# CITY OF ALBUQUERQUE

November 13, 2018

**RE: Overture Senior Active Adult  
6410 Palomas Ave NE  
Grading and Drainage Plan  
Engineer's Stamp Date: 10/17/18  
Hydrology File: D18D056A**

**RE: OVERTURE SENIOR ACTIVE ADULT  
GRADING AND DRAINAGE (FILE: D18D056A)**

ENGINEER'S SEAL JOEL D. HERNANDEZ P.E. #17893	OVERTURE SENIOR ACTIVE ADULT GRADING AND DRAINAGE PLAN TIERRA WEST, LLC 5571 MIDWAY PARK PLACE NE ALBUQUERQUE, NM 87109 (505) 858-3100 www.tierrawestllc.com	DRAWN BY DY DATE 9/20/18 2017086-GRB
		SHEET # C2 JOB # 2017086

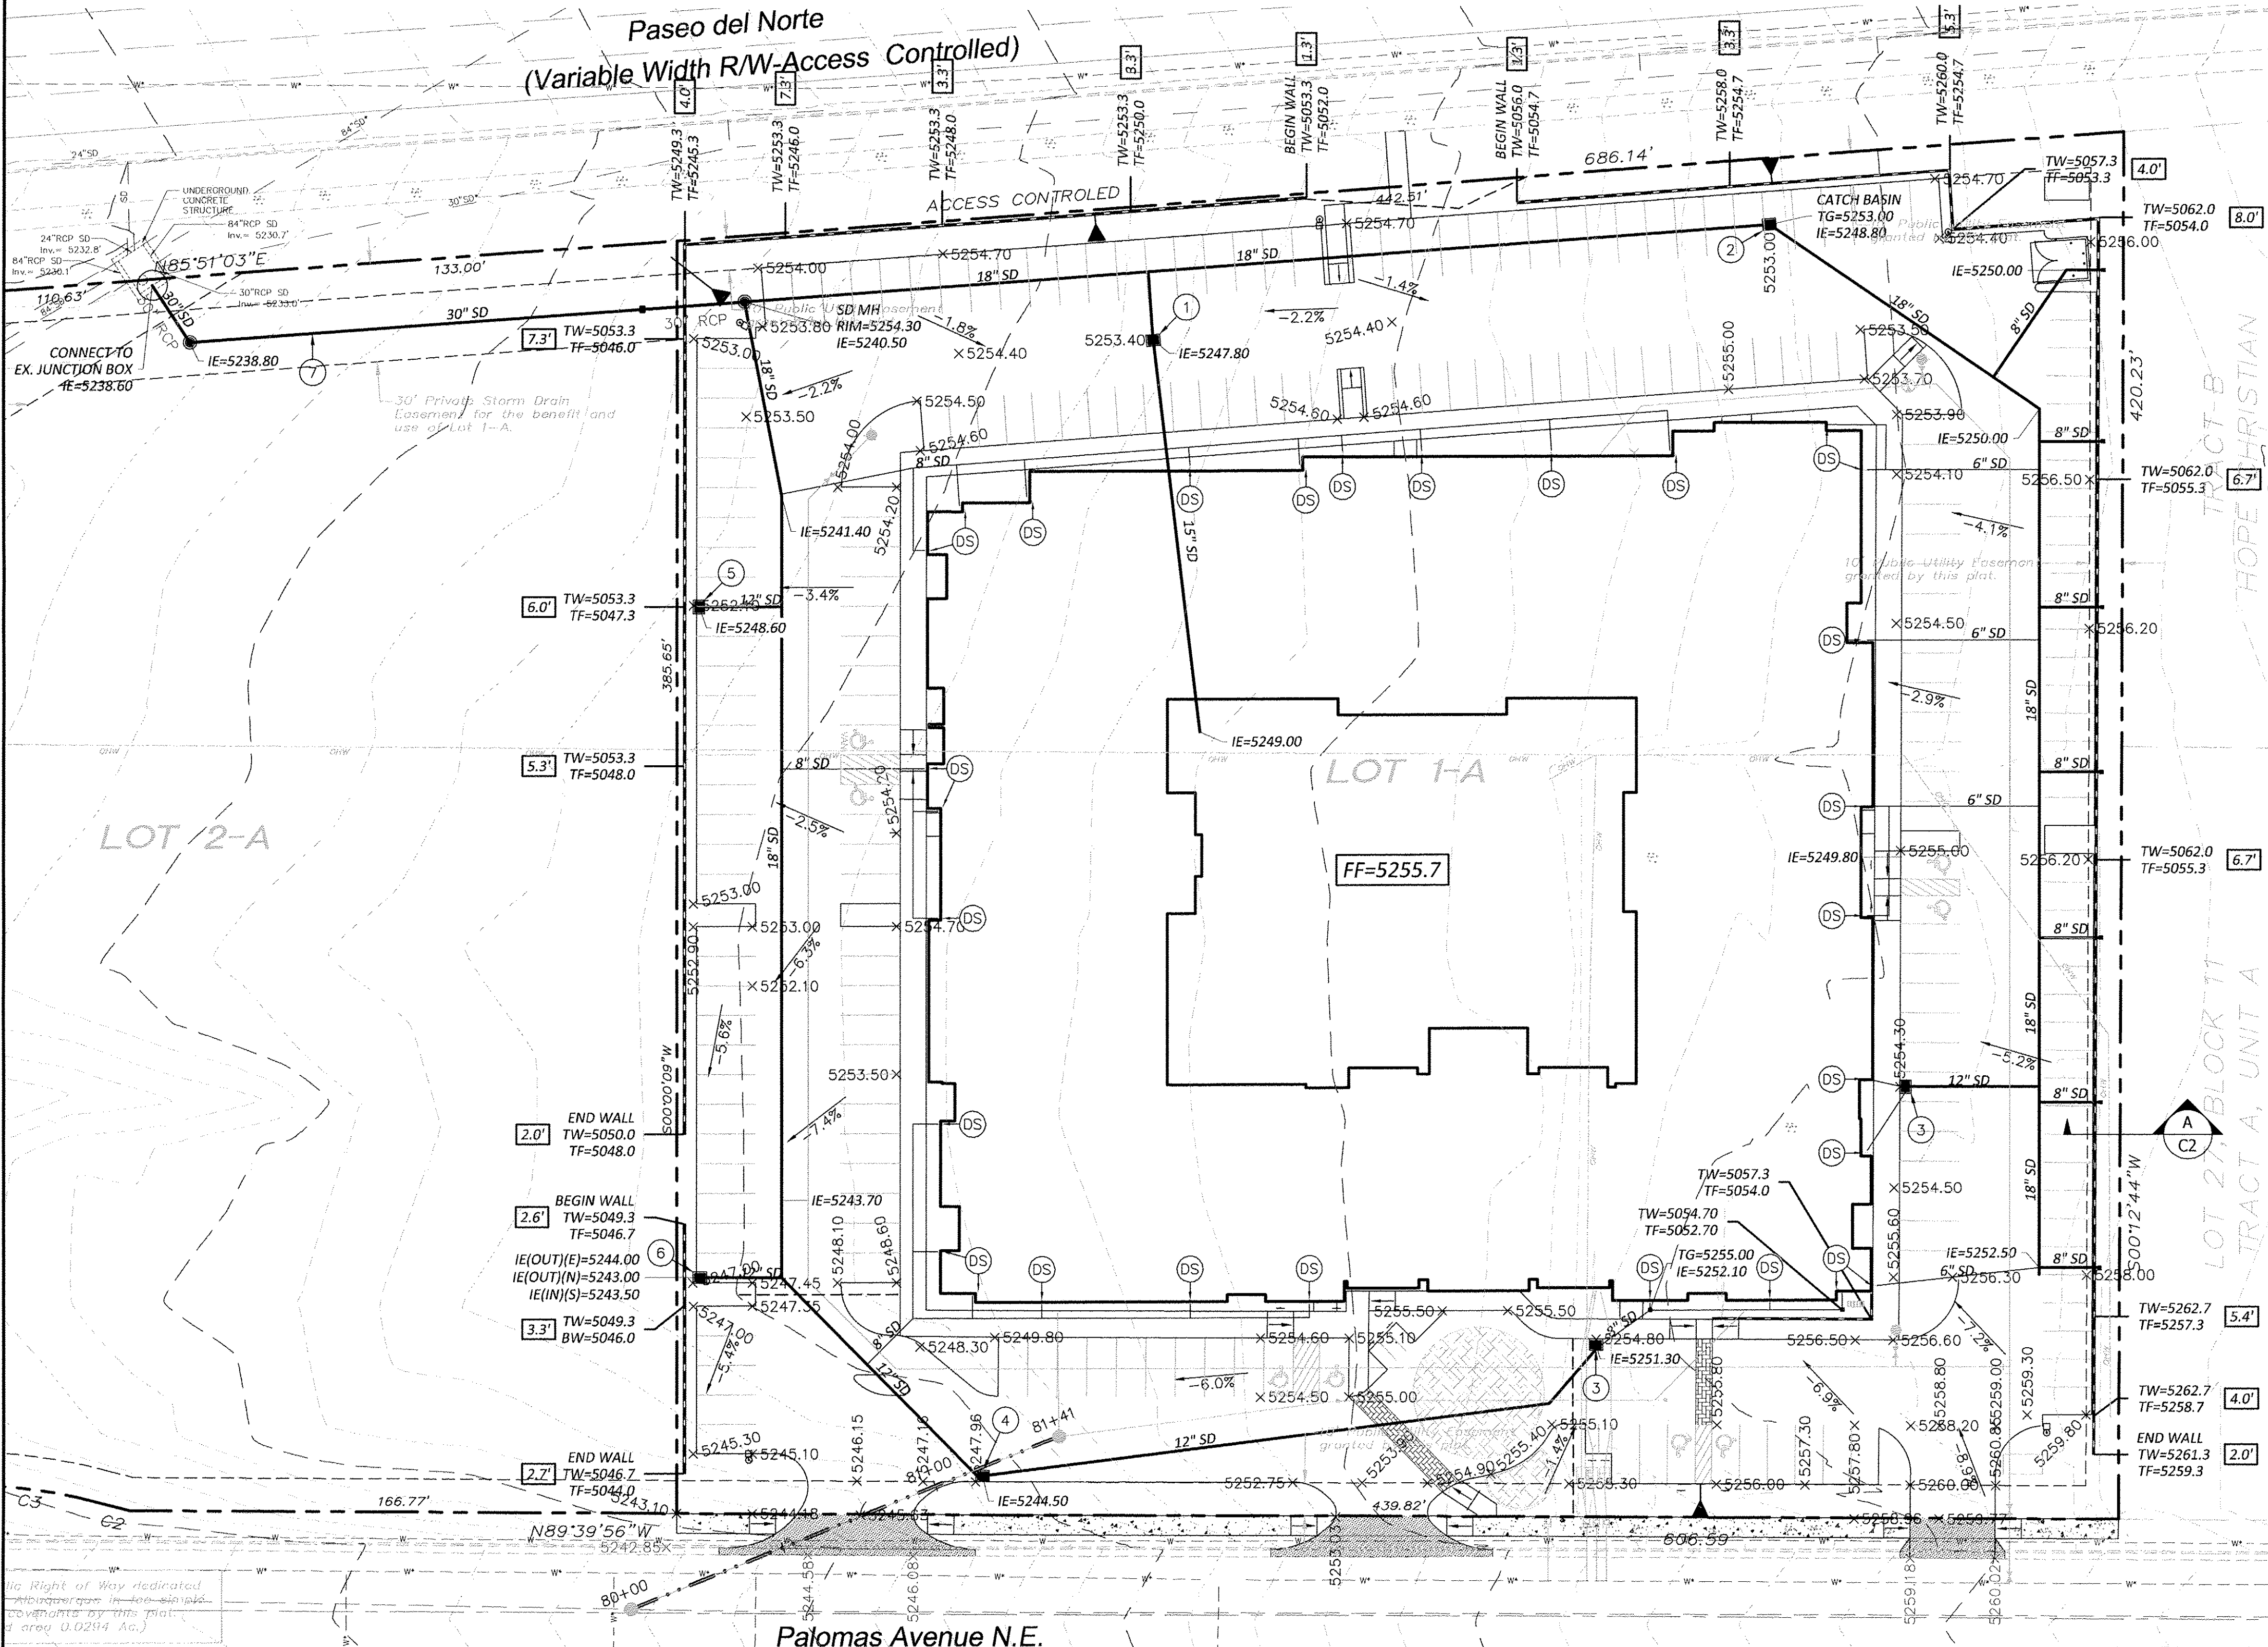
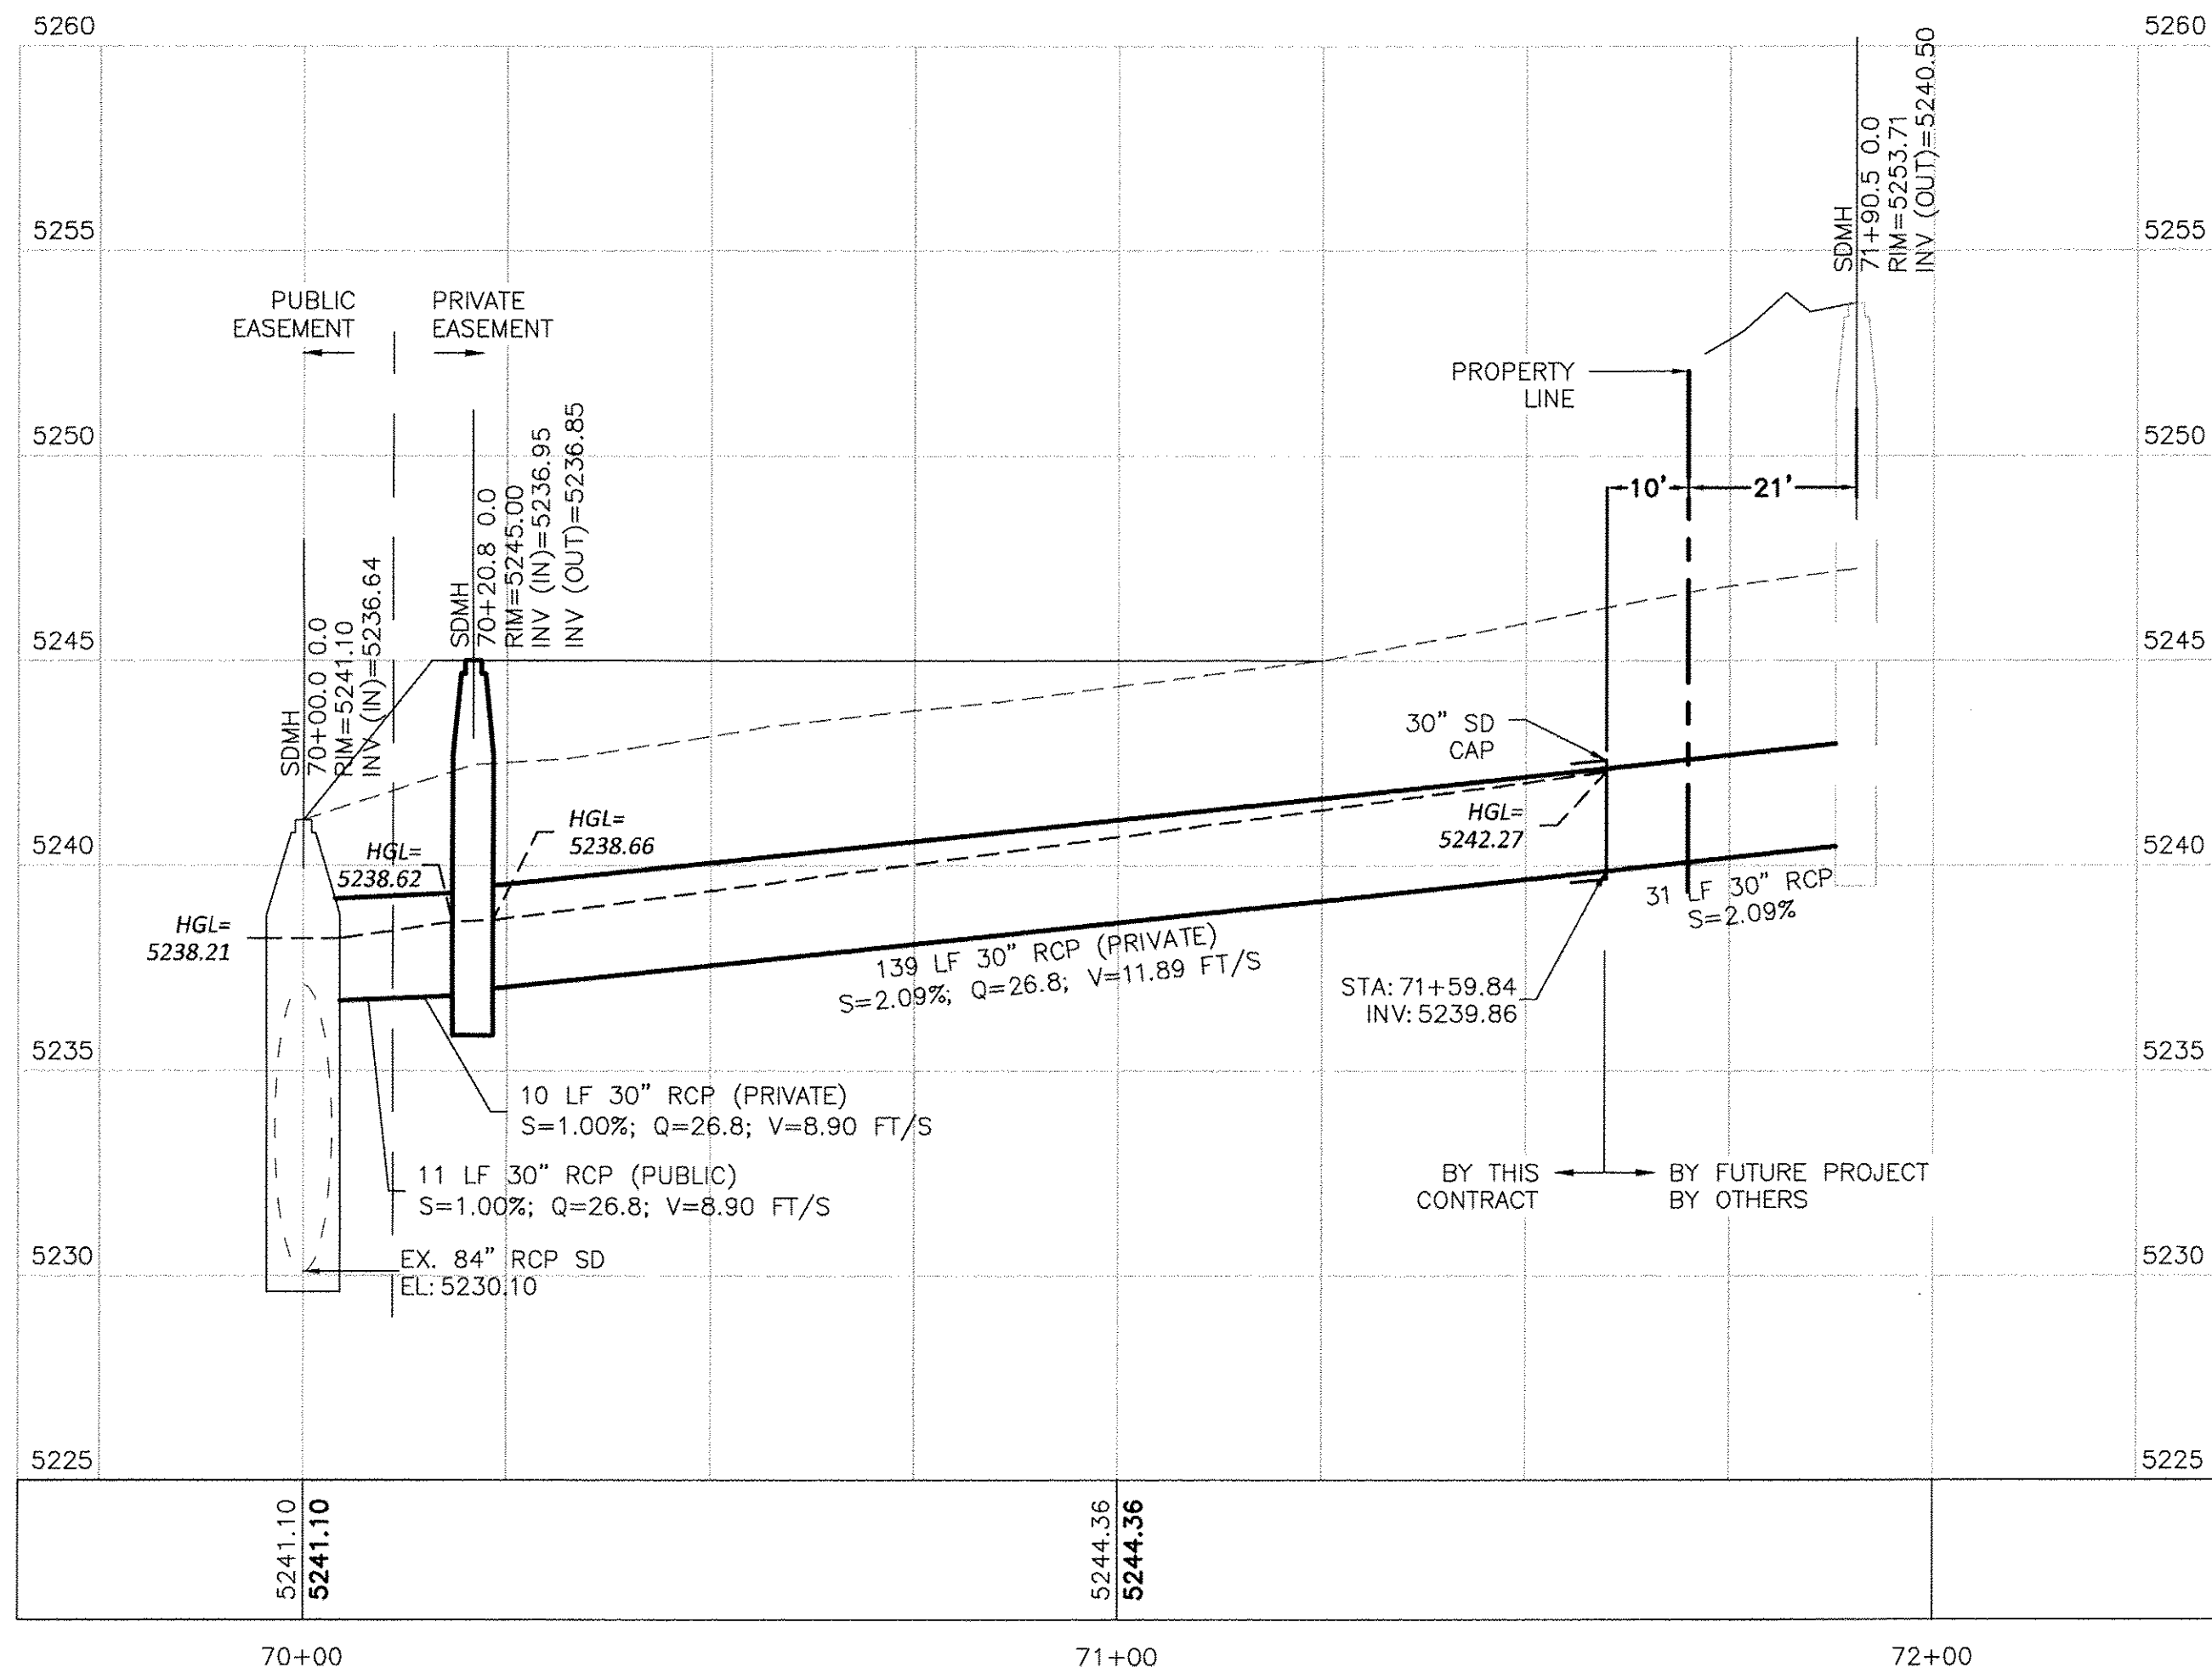
2. Please provide the FIRM Map's effective date.

3. Please provide the benchmark information for the survey contour information provided.

5. Please add a note requesting a waiver for the first flush volume requirement. Also add a note stating, "The required first flush volume for the 142,764.70 SF of impervious cover is 4,045 CF."

**RESPONSE: The FIRM Map's effective date is 08/16/2012. We added this notation to Sheet C2.**

**RESPONSE: We added the benchmark information to Sheet C2 (located in Paseo Del Norte sidewalk, near northeasterly property corner).**

**RESPONSE: We have added a note indicating the first flush requirement and formally requesting a waiver to allow in-lieu fee payment onto Sheet C2.**

4. Please provide a section of the proposed retaining wall along Paseo del Norte near the Northwest corner of the site and a section of the proposed retaining wall along the western property line.

**RESPONSE: The section views requested are now included on an added Sheet C2.1 for clarity.**
